**From:** David Margolis-Pineo  
**To:** Errico Thomas; Jean Fraser; John Peverada  
**CC:** Jeremiah Bartlett; Philip DiPierro  
**Date:** 4/11/2014 1:24 PM  
**Subject:** Fwd: RE: 118 on Munjoy Hill - Revised Construction Management Plan

**From:** Jean Fraser [mailto:JF@portlandmaine.gov]  
**Sent:** Wednesday, April 09, 2014 2:59 PM  
**To:** Bourke, Jeanie; Machado, Ann; Stanley, Virginia  
**Cc:** Bergeron, Rick; Carey, Tom; Greer, Tom; Lloyd, David; Newell, Chip; Pitman, Cordelia  
**Subject:** Re: 118 on Munjoy Hill - Revised Construction Management Plan

On January 28<sup>th</sup>, 2014 the Portland Planning Board requested nine (9) conditions of approval of a Level III Final Site Plan and Subdivision proposal for "118 on Munjoy Hill" Condominium 12 unit residential, and 2 unit commercial, condominium #2013-255 located at 118 Congress Street . CBL:16-D-2

Construction Management Plan

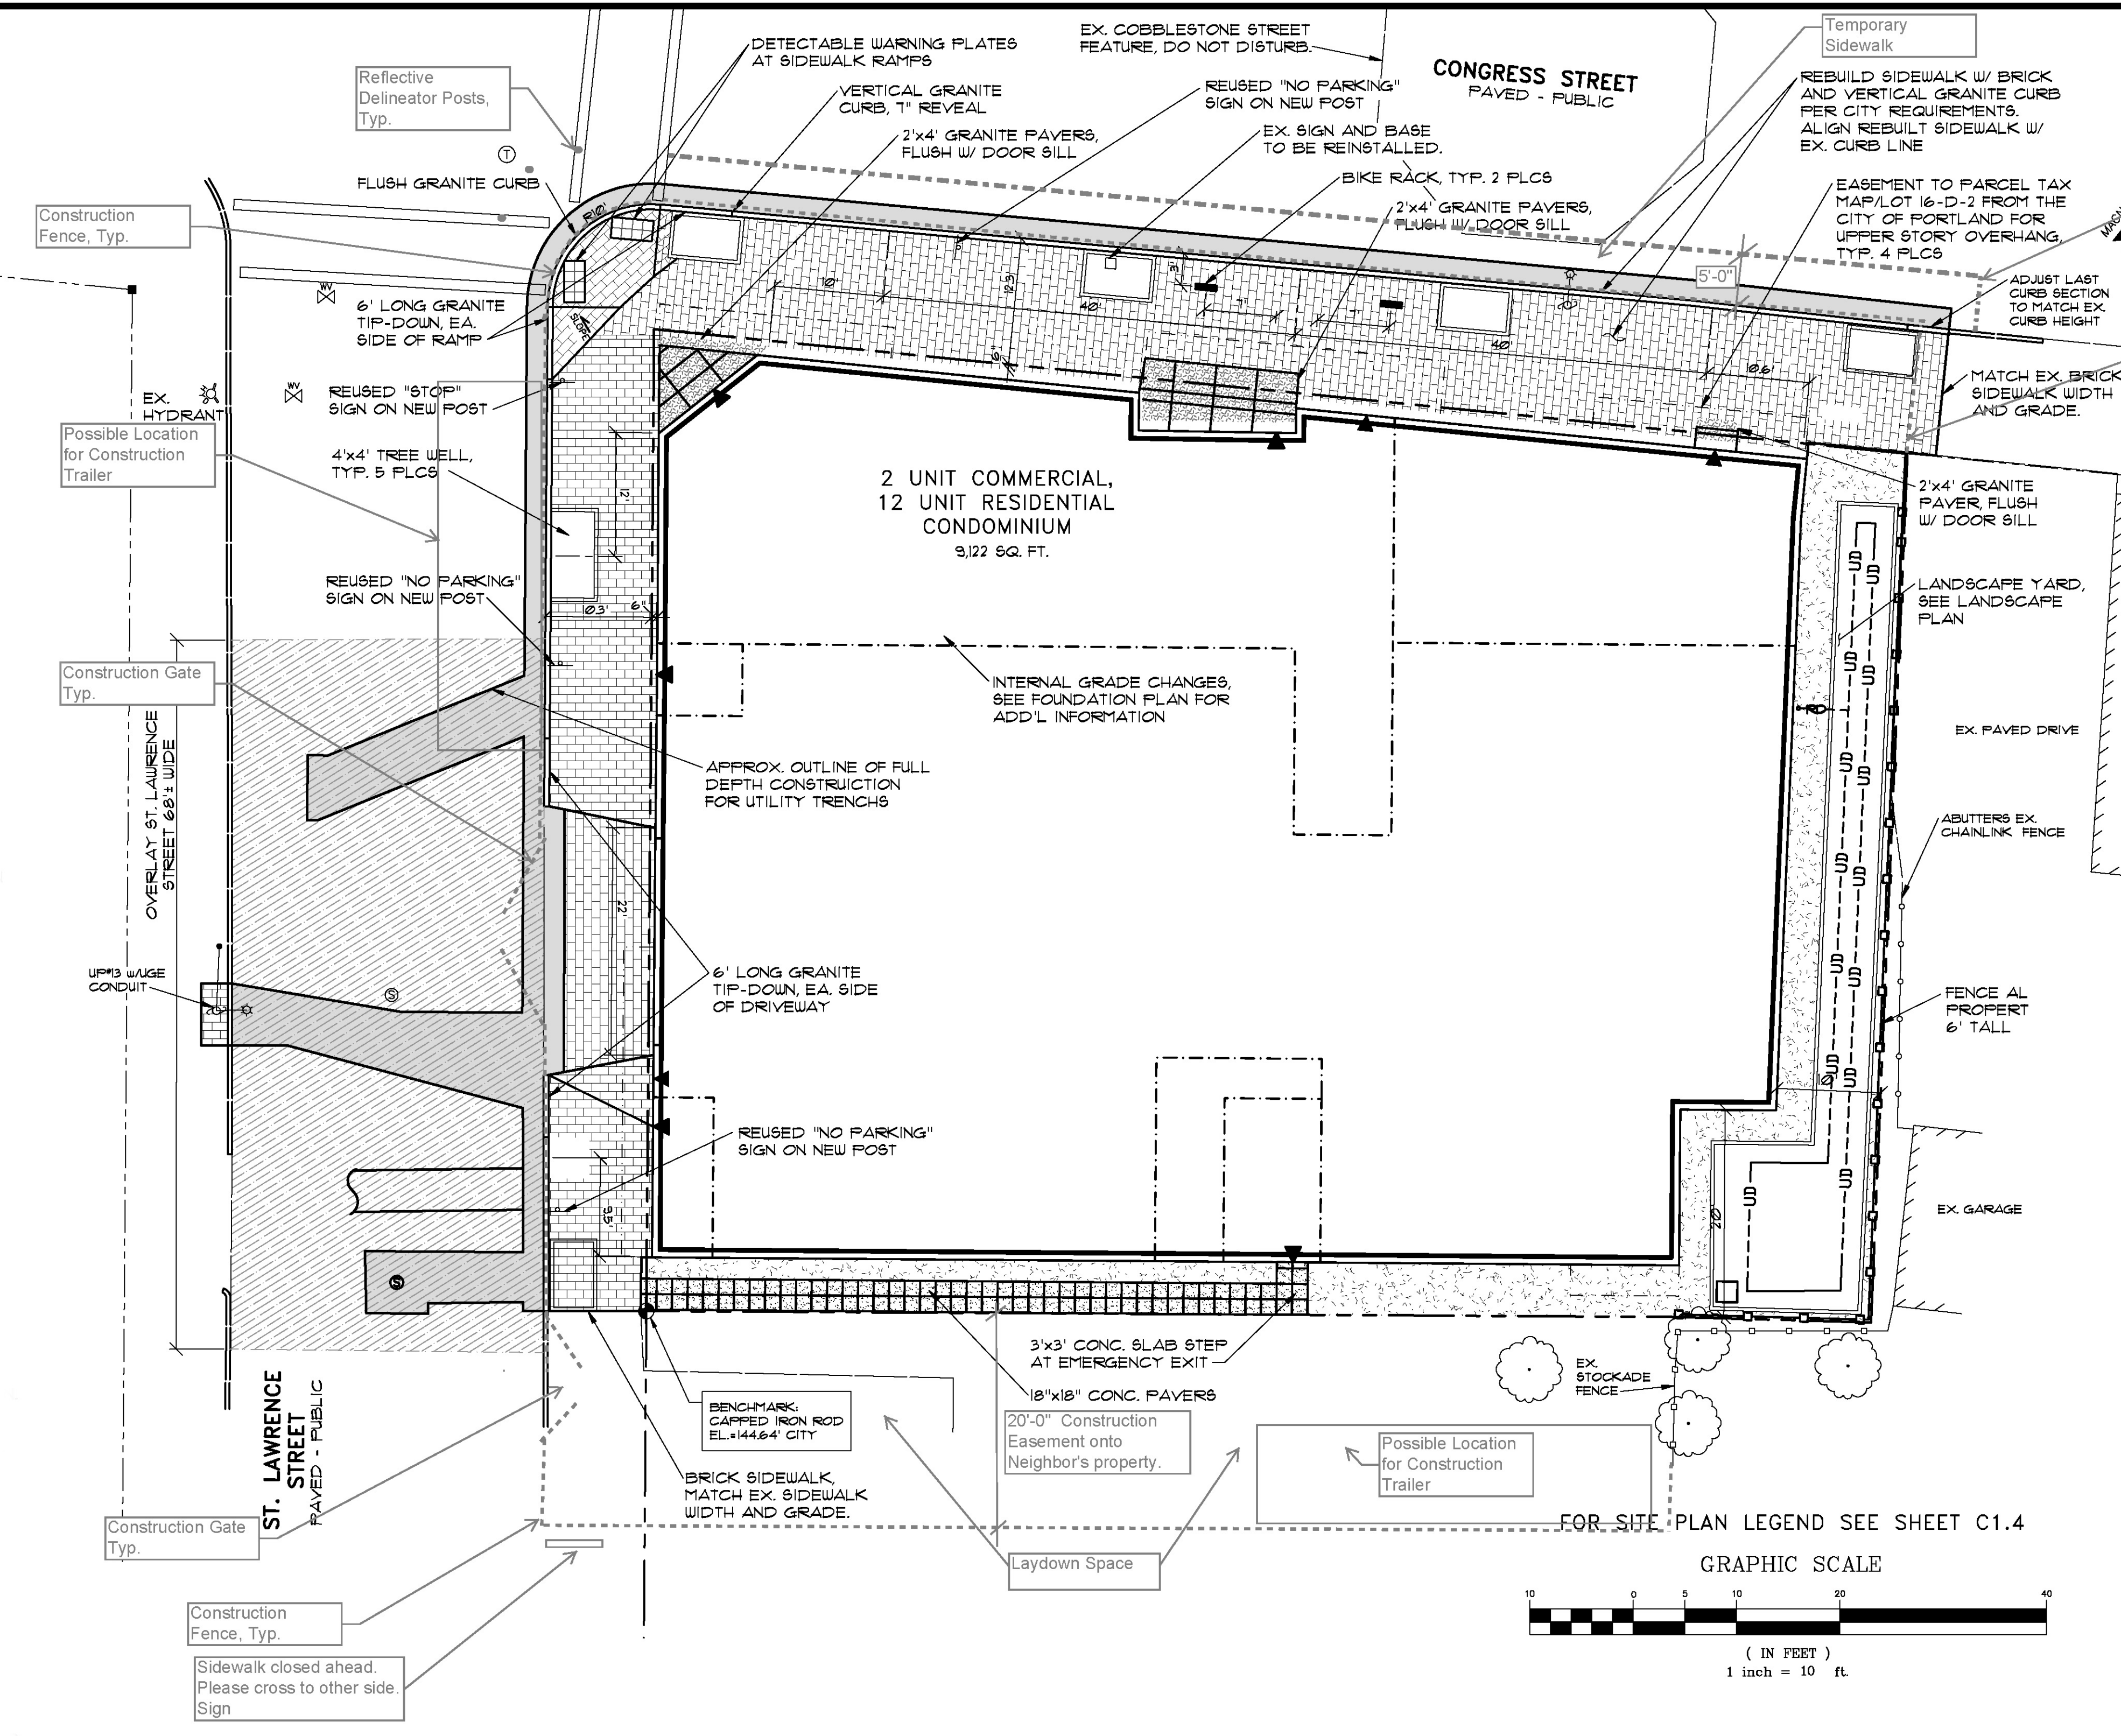
DPS have the following comments on the CMP letter and plan submitted April 1, 2014 - please note that Tom Errico, Traffic Engineering reviewer, Captain Chris Pirone of the Fire Department, and John Peverada, Parking Manager, all concur with these comments:  
We would like the applicant to eliminate the proposed mid-block "temporary crosswalk" on St. Lawrence St and post a "Sidewalk Closed Ahead - Cross Here" sign at the intersection of Monument and St Lawrence; The proposed temporary sidewalk layout (Congress Street) is acceptable to Public Services but will occupy approximately four parking spots on Congress Street. One is a U-Haul Car Share spot. At least one week before the temporary sidewalk is installed, the developer will need to work with John

Peeverada to relocate the Car Share location. Since four parking locations will be occupied, there will be a \$15/day or \$420 fee per week for occupying these parking spots.

Please revise the plan as requested - also it would be easier if the notes in the letter were added to the plan where not already identified, so all the information is on one plan. Please send the final version of the CMP to me so I can get a final "sign off" and confirm to you that the condition has been met.

Attached please find a revised Construction Management Plan dated 4/10/14. Wright Ryan Construction incorporated the changes requested in your email below.
